Application no: 23/01271/DISC

Location: Axis J9 Phase 3, Howes Lane, Bicester

Transport Development Control

No objection to discharge of condition 11 - visibility splays

03 WELD MESH FENCING
014 2m high typical details

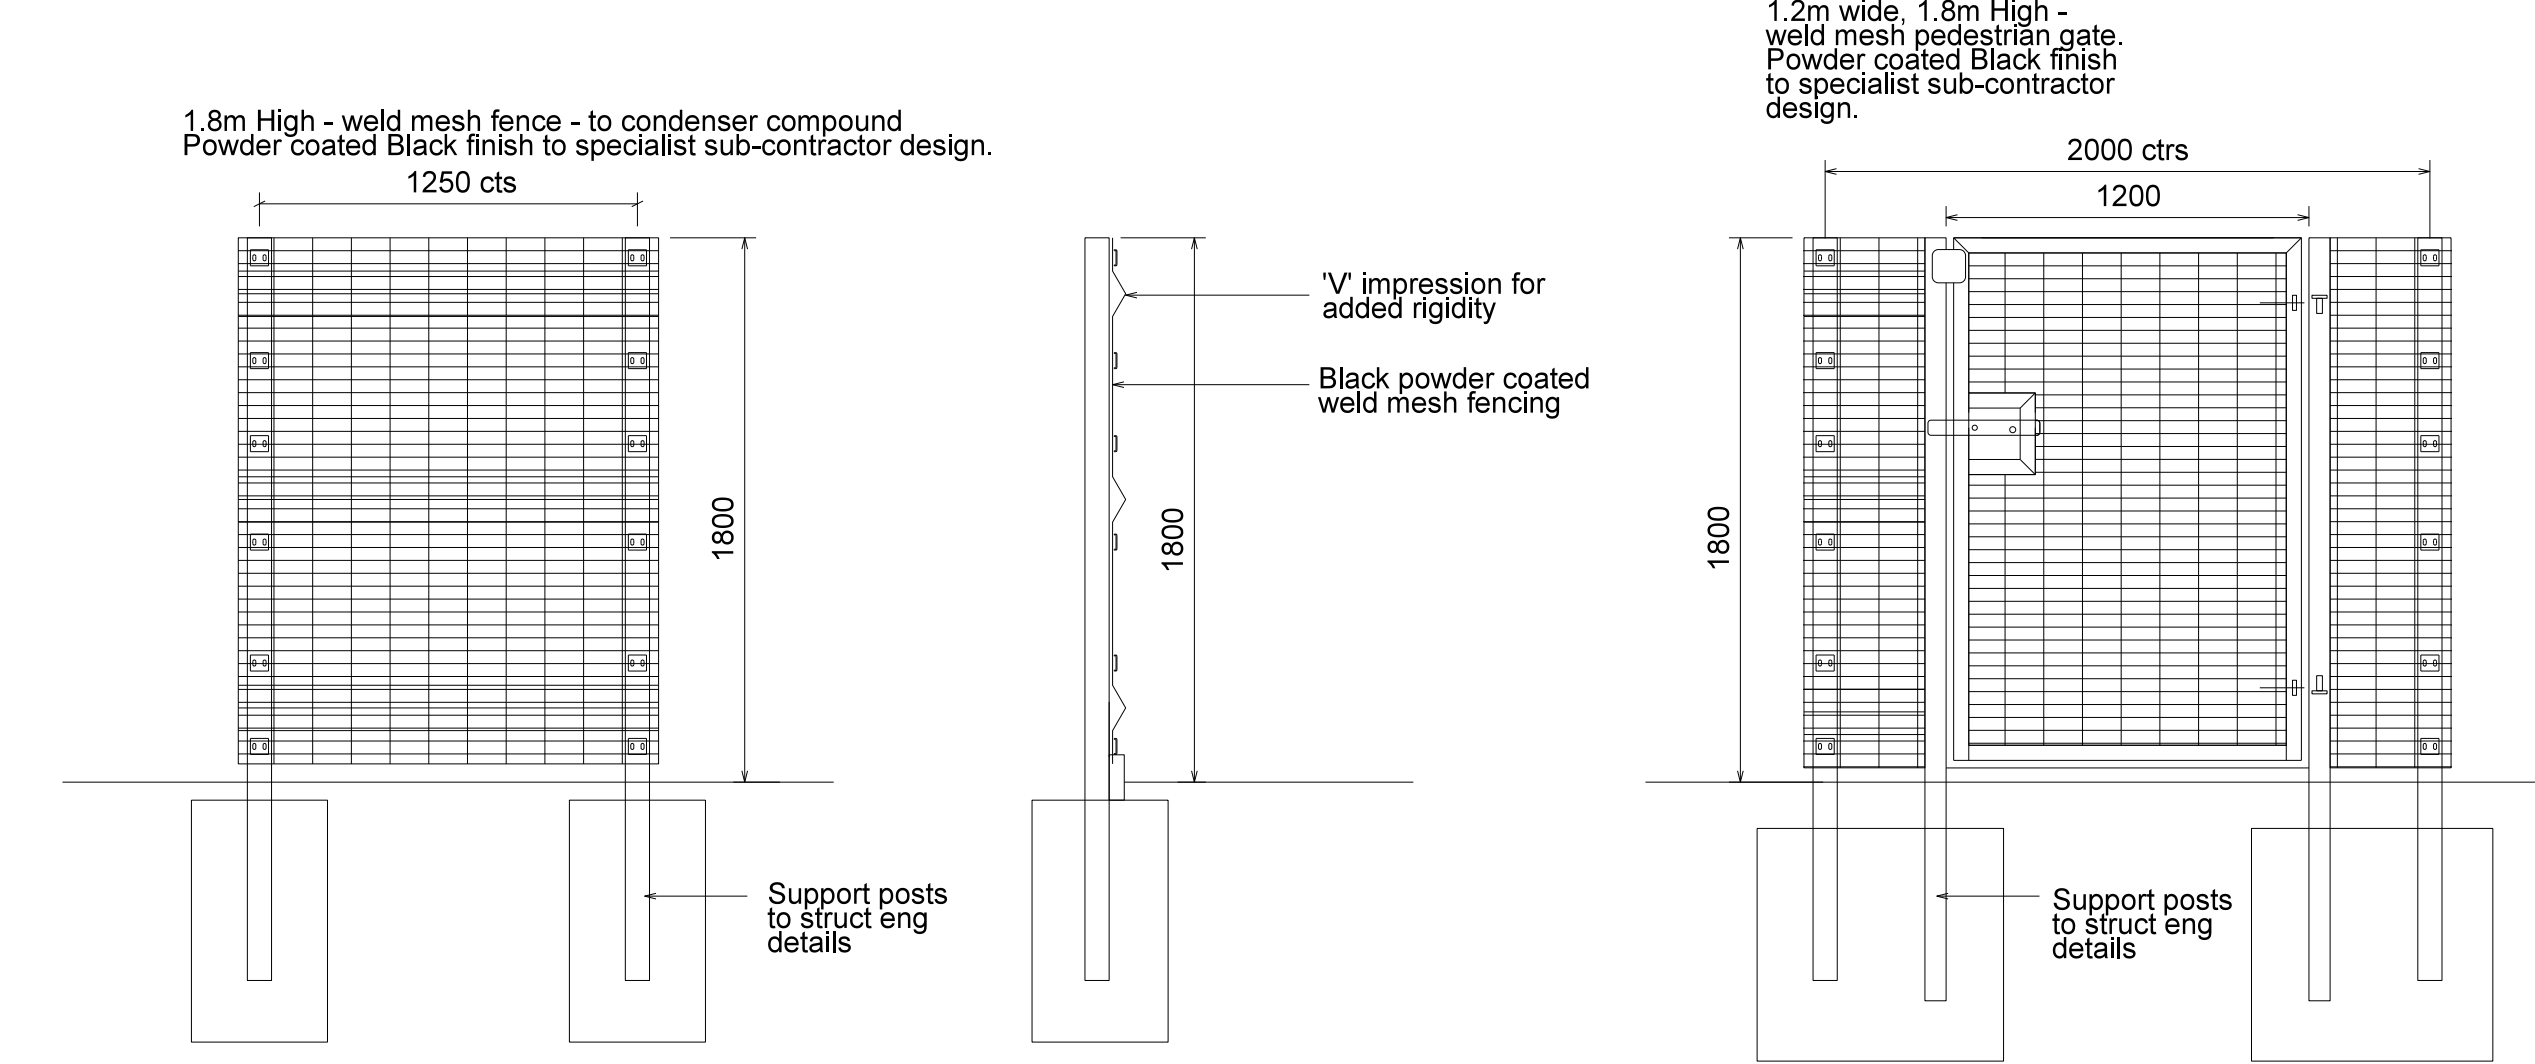
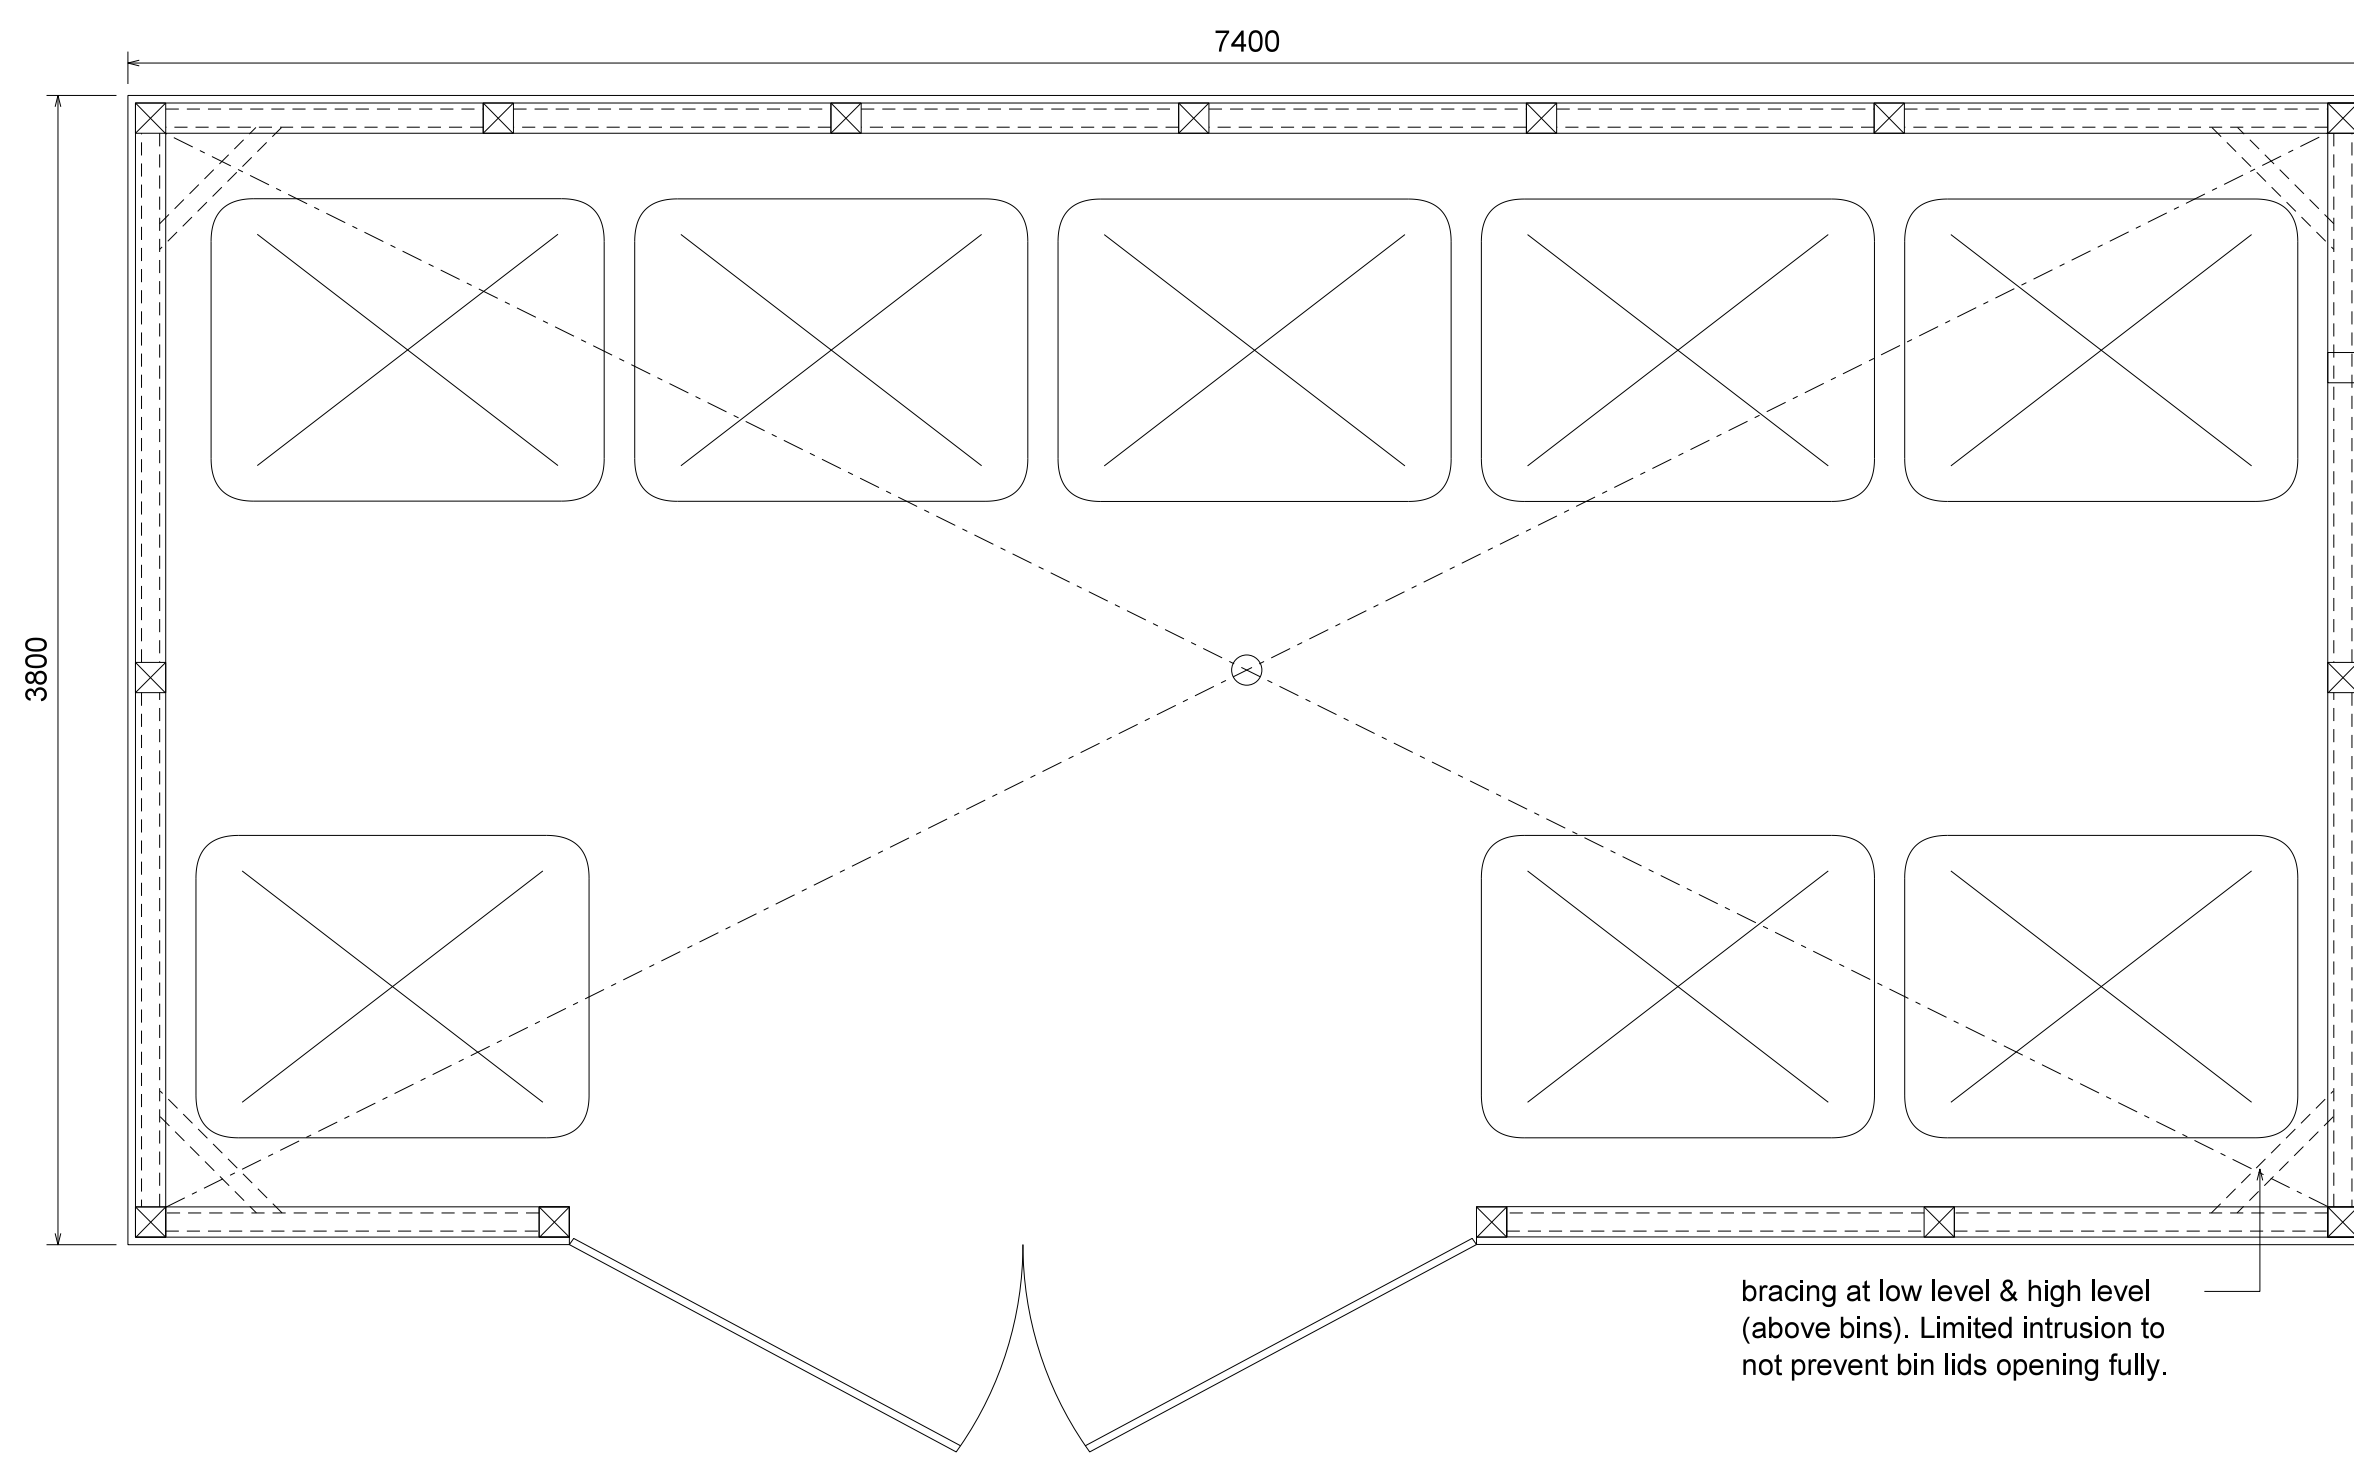
Vehicular vision splays are acceptable for likely speeds. The applicant has confirmed that the boundary would be weldmesh with no vegetation, which means visibility between drivers and pedestrians on the footway would also be acceptable.
